RESIDENT PARKING
CHISHOLM CARRIAGE LOT
ON CHADWICK STREET

APPLICATION FOR CERTIFICATE OF OCCUPANCY FOR USE OF PREMISES

92-96 Chadwick St.

Building permit to construct a parking lot for 22 cars on land owned and contiguous to the Thomas House Interns Residence to which this parking is accessory is being issued subject to the following:

MAINE MEDICAL CENTER	
92-96 CHADWICK RESIDENT PARKING CHISHOLM-CHADWICK ST	
DRWG:	
DR. BY: D.W.B.	DATE: 5/31/67
REV. 6/1/67	SCALE: 1" = 16'

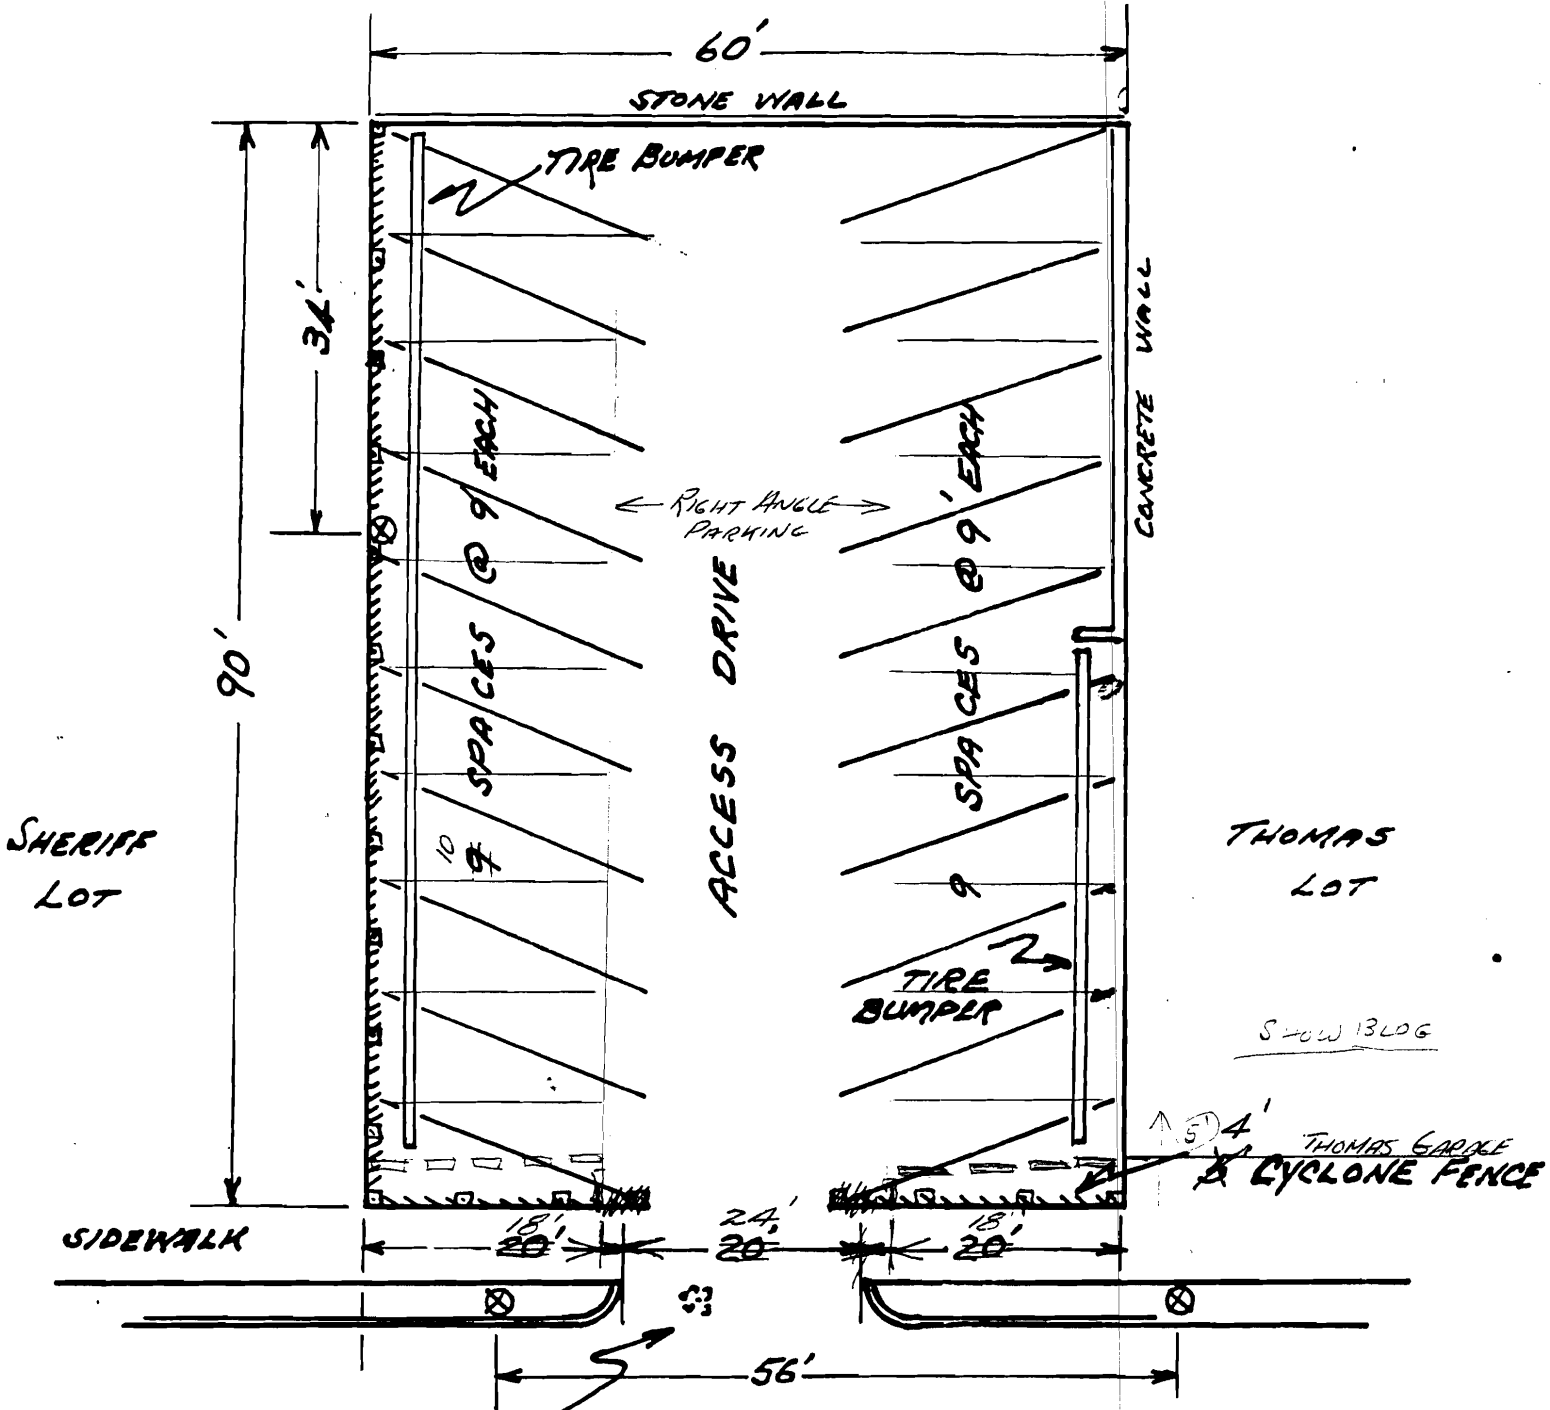
The cyclone fence required by the Zoning Ordinance is to be 4 feet in height along the Chadwick Street line and not over 4 feet in height within 25 feet of this line.

Your letter and authorization to proceed with the parking lot at 92-96 Chadwick Street has been received, and the exception in relation to the cyclone fence has been noted and will be complied with.

The enclosed is a sketch which is an addendum to the previous sketch on Resident Parking at 92-96 Chadwick Street, and it shows the requested 5 foot spacing between the first right angular parking space and the edge of the sidewalk.
